DRAFT
Framework Plan
Himley Village
Bicester

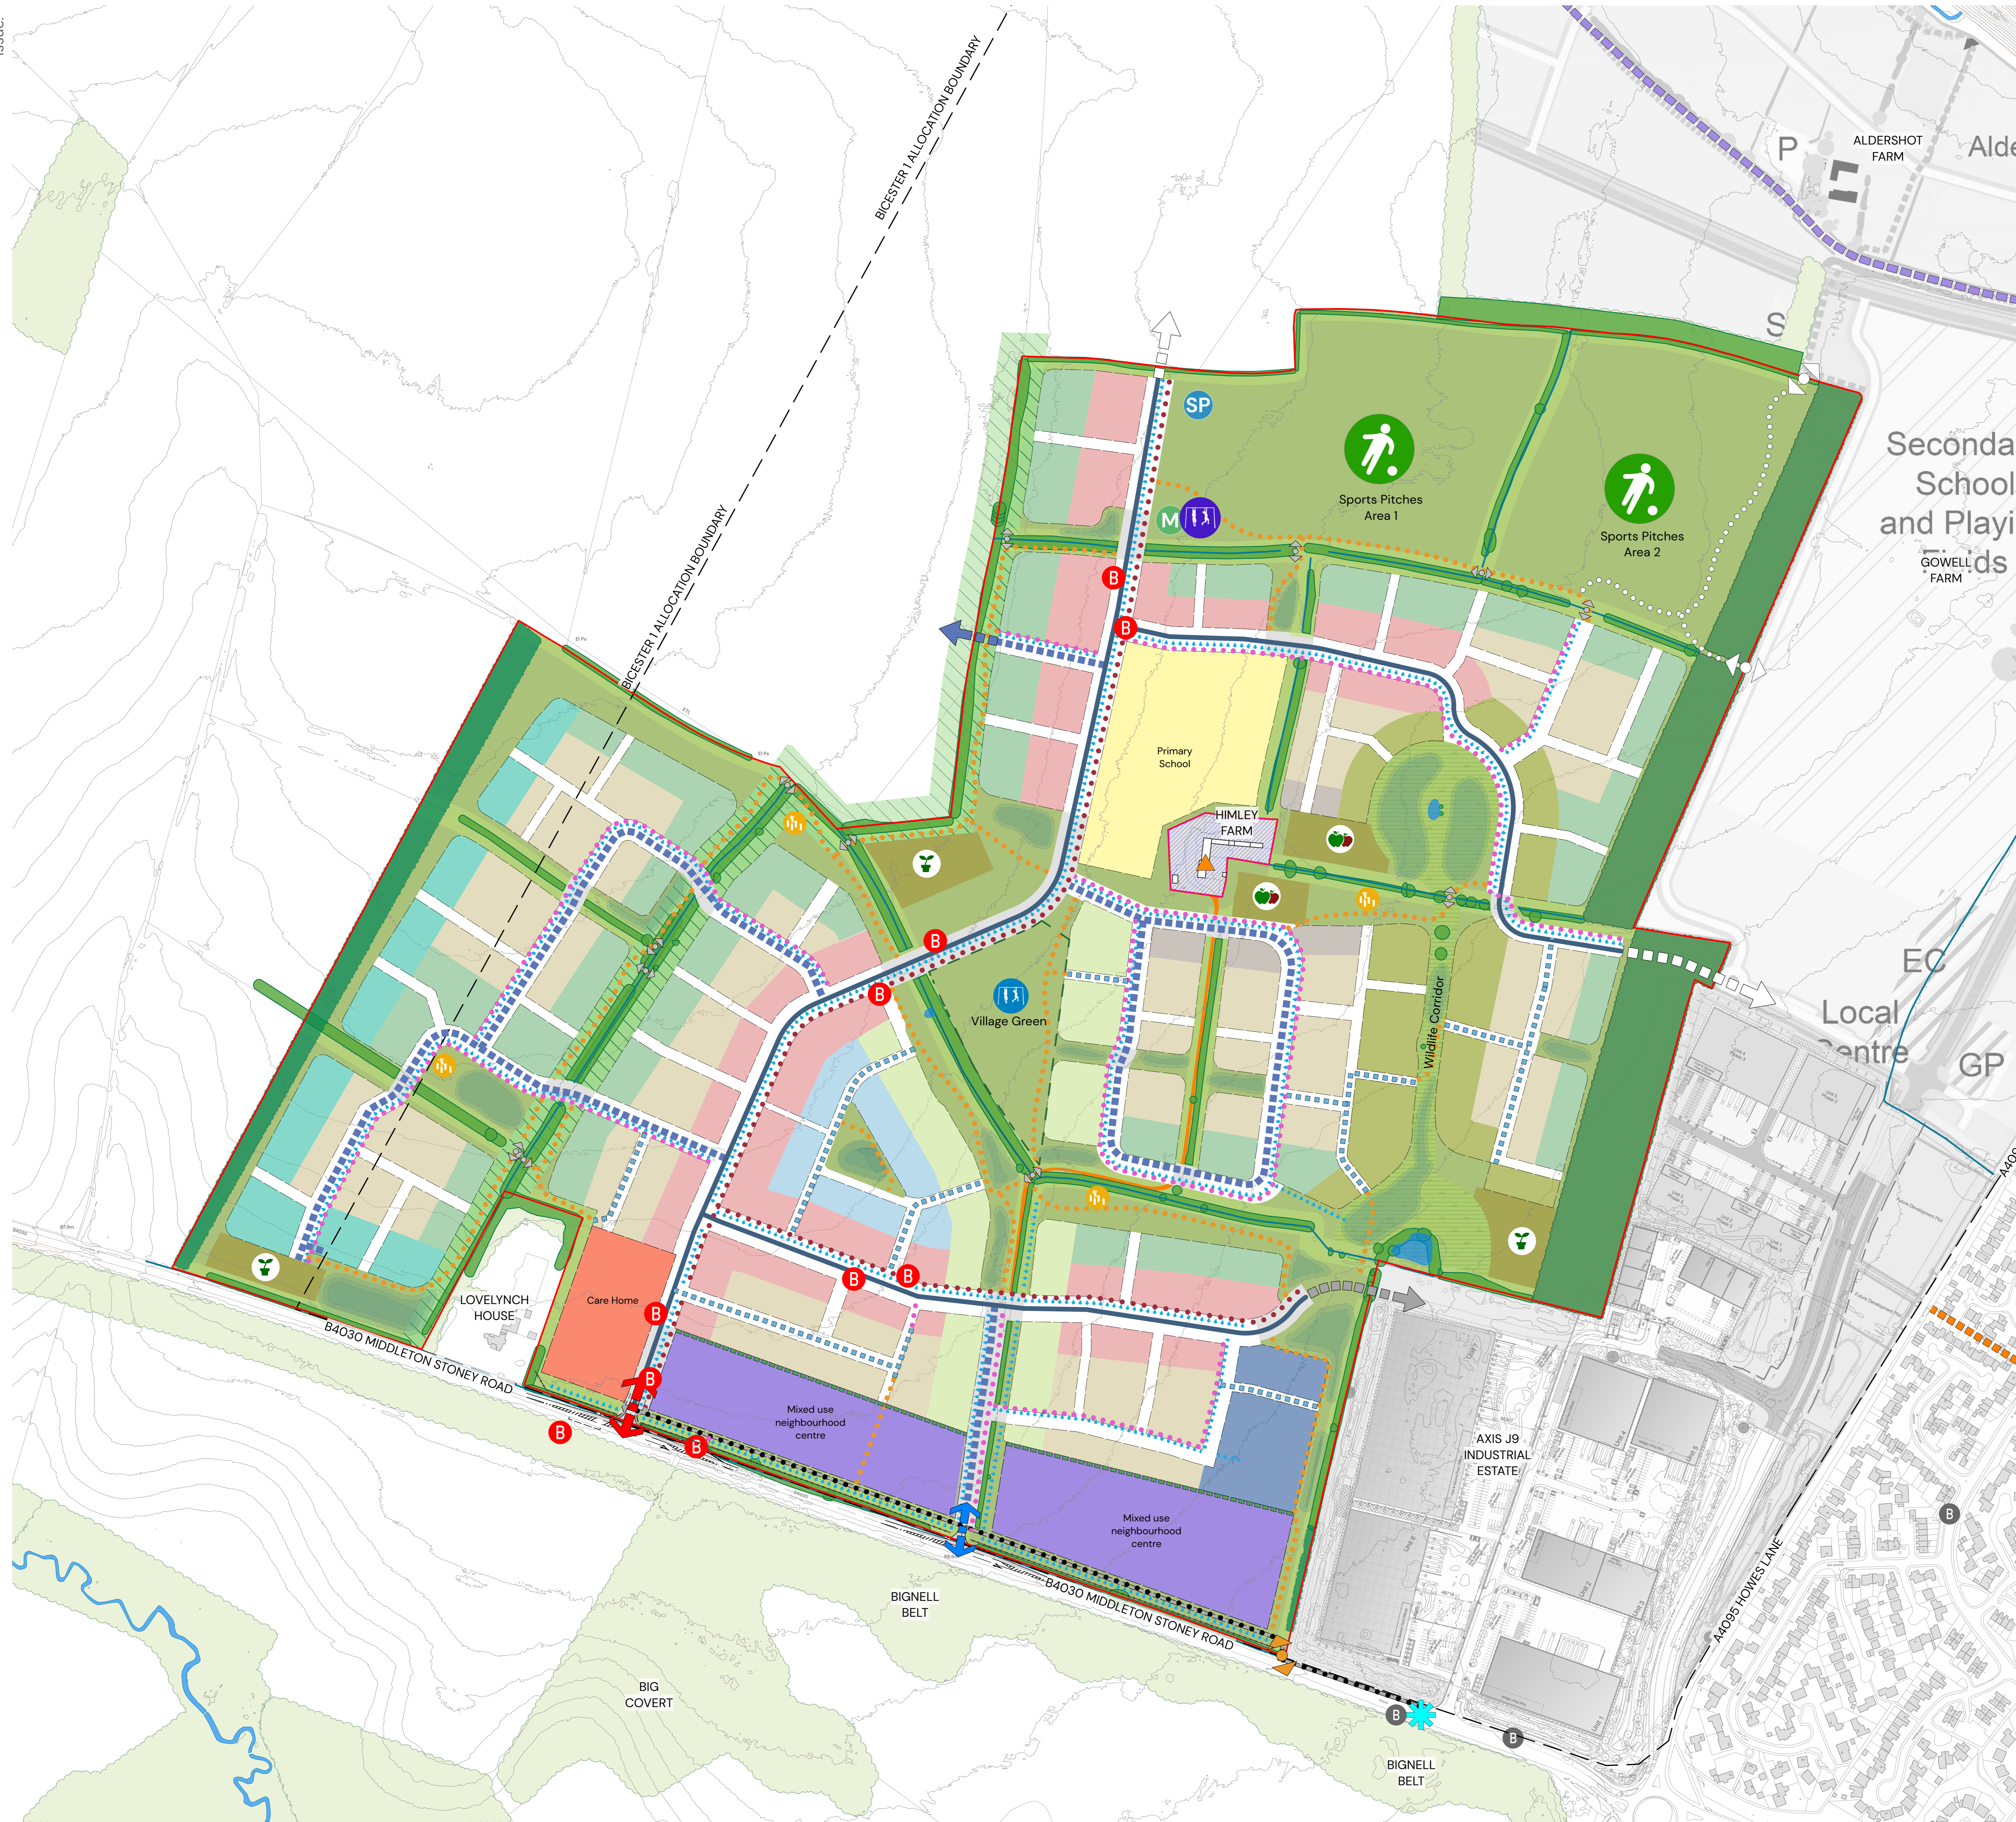
Spine road and higher traffic streets – cycle lane required on both sides as per preapp advice – with direction of traffic

If this is to become a vehicular link to an adjacent site in future it should be designed accordingly, with cycle lane on both sides as per spine road, and adopted to the boundary

Likely to be main route towards local centre within Aldershot Farm site – needs to be a primary cycle route – 3m bi-directional plus 2m footway

Ped/cycle onnection required here

In the Aldershot Farm proposals this N-S route wouldn't exist – this would be the boundary with the school playing field. Connection point probably not required here.

Make provision for ped/cycle link along this boundary

Off carriageway cycle facilities not needed on low traffic streets – per LTN 1/20

Segregated cycle facilities (as per spine road) needed here as key route to school – as per spine road

Will probably be main cycle/ped access towards secondary school. Needs to be segregated – 3m bi-directional cycle track plus 2m footway – direct route all the way from site boundary to spine road

Spine road and higher traffic streets – cycle lane required on both sides as per preapp advice – with direction of traffic

Needs to be primary cycle route linking all the way from Middleton Stoney Rd to northeastern corner of site

This connection will need to be provided according to S106 trigger. Should be designed as primary cycle route alongside bus link and land dedicated up to site boundary until that point.
